Re: Good Hope Hospital Addition
410 Denim Drive
Erwin, NC 28339
Trakit# BCOM 1906-0004

The plans for the addition to the existing facility has been reviewed but not approved. The following items must be corrected before the plan can be approved.

1 FLOOR PLAN
 1/8" = 1'-0"

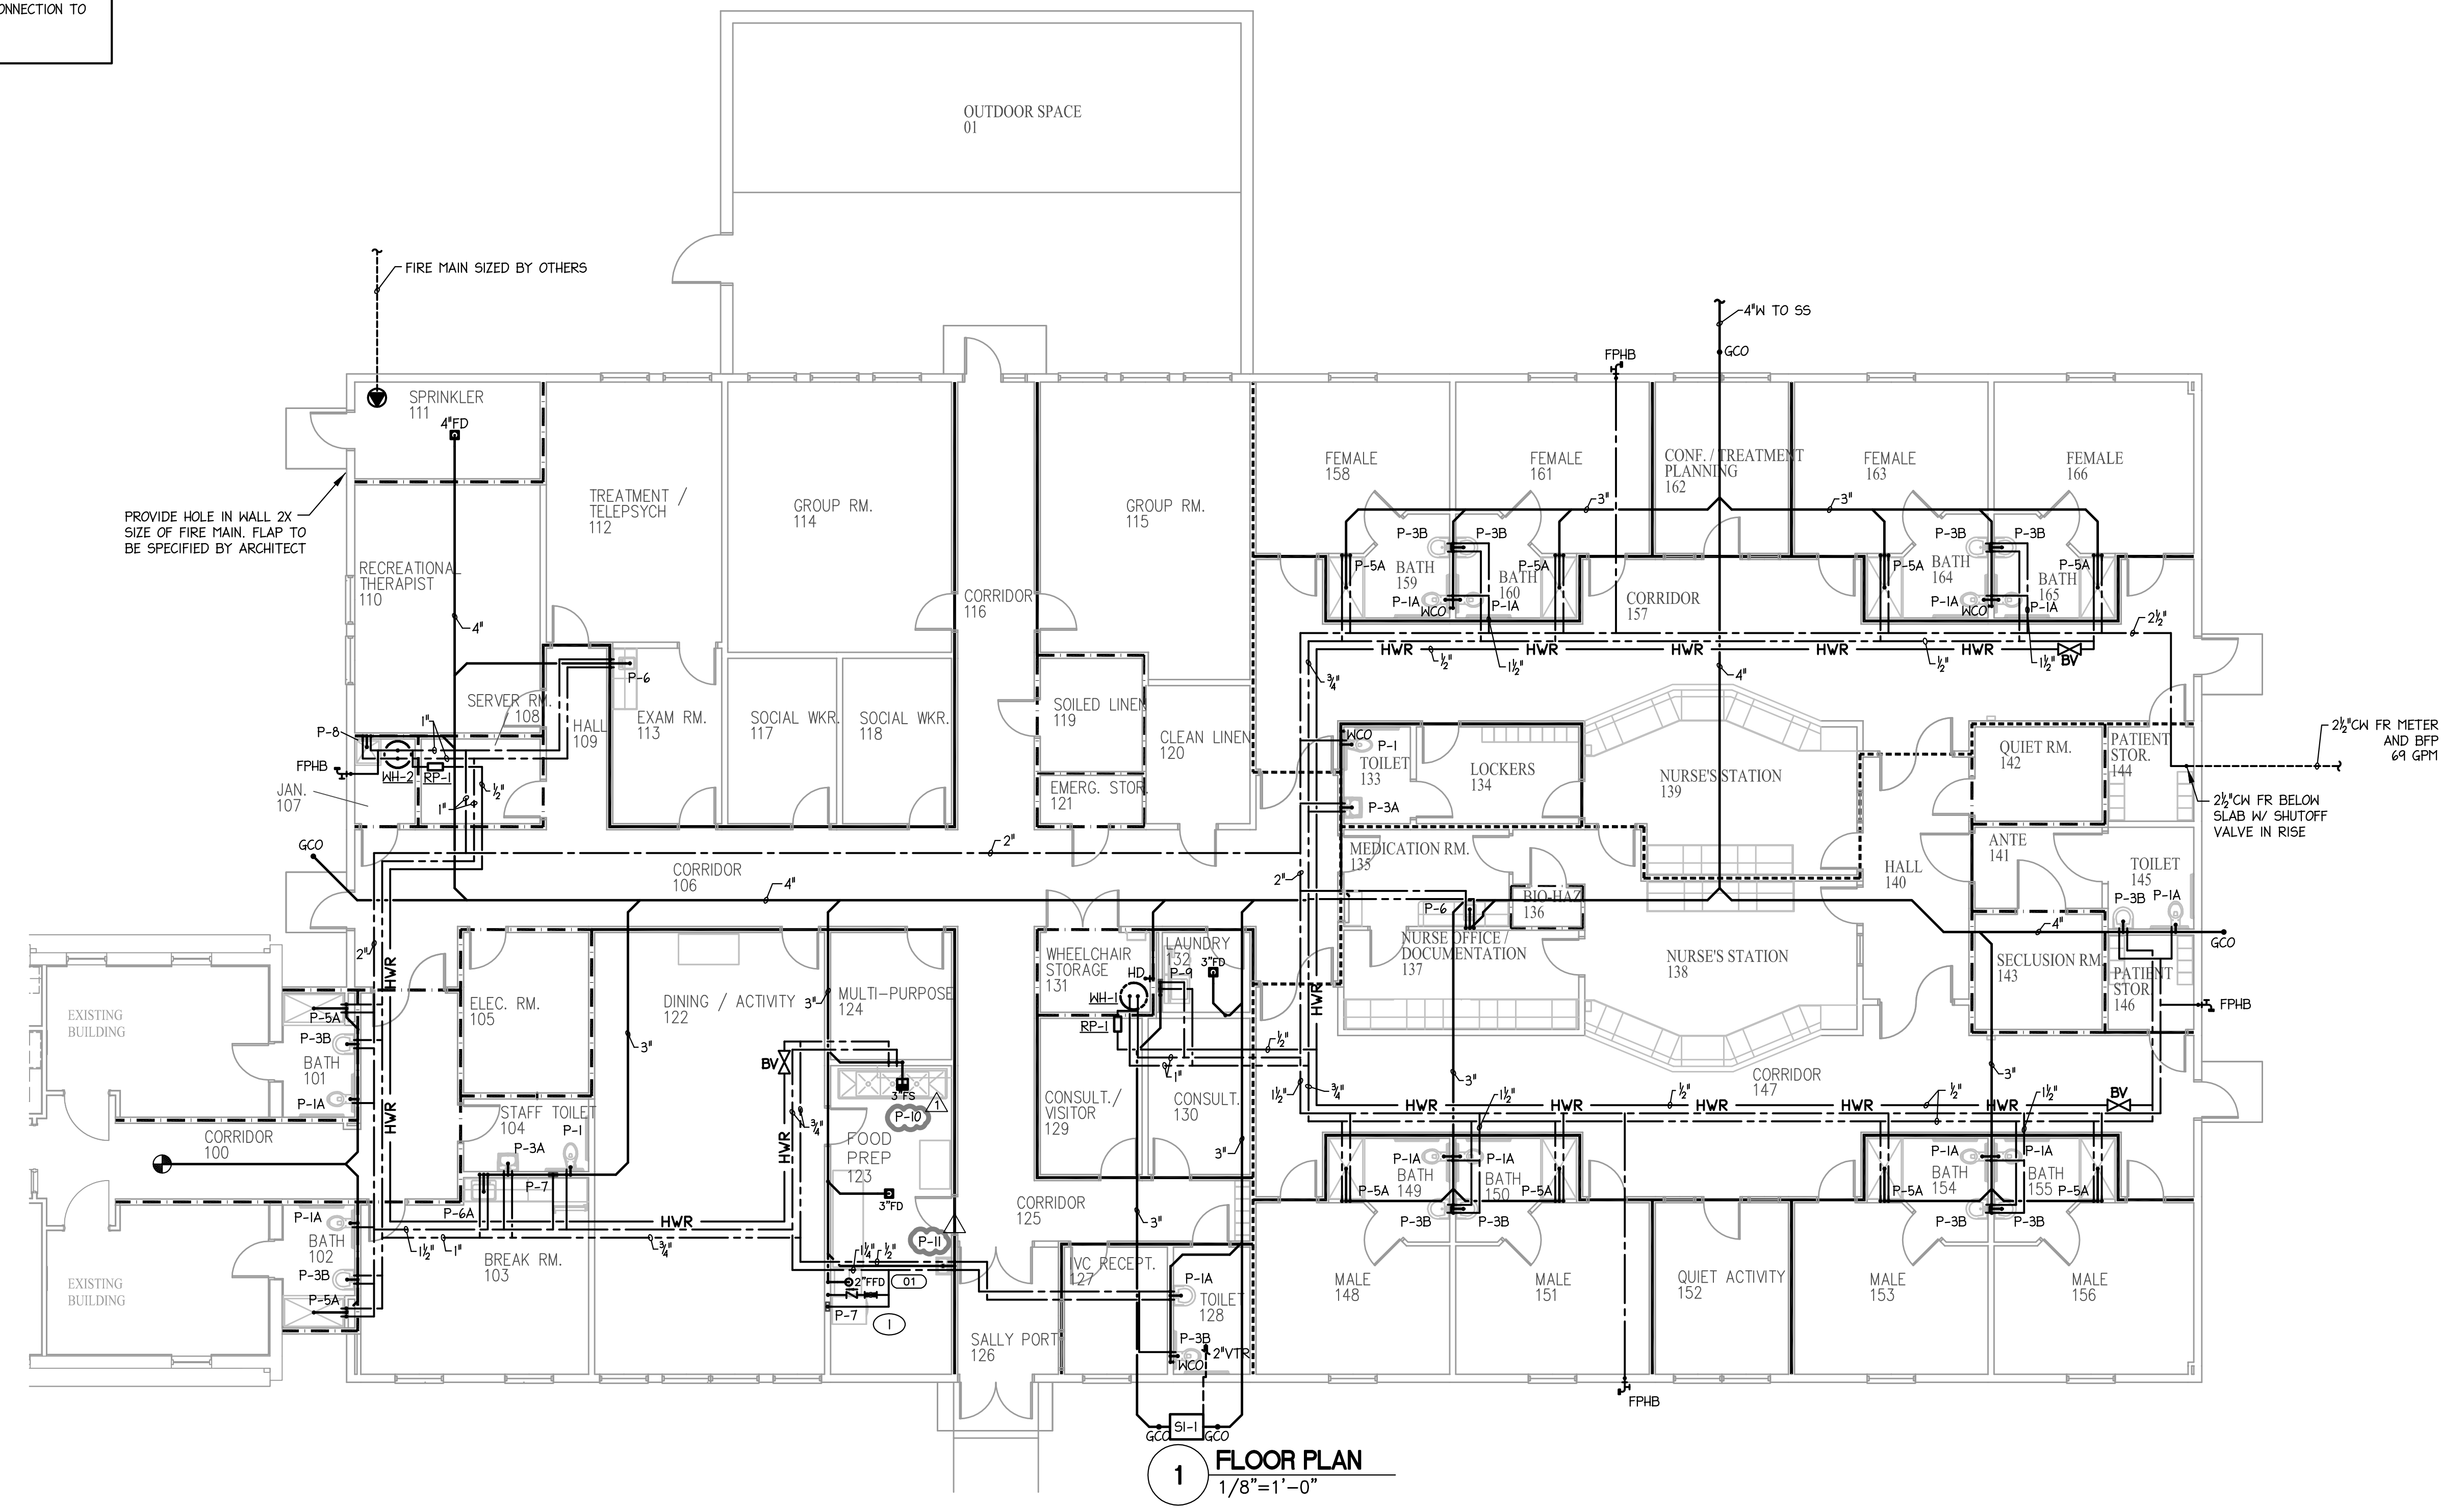
1. The proposed two-compartment, one drainboard kitchen sink must be replaced with a three-compartment, two drainboard sink.

In addition, please submit equipment specification sheets for the proposed ice machine and kitchen refrigerator.
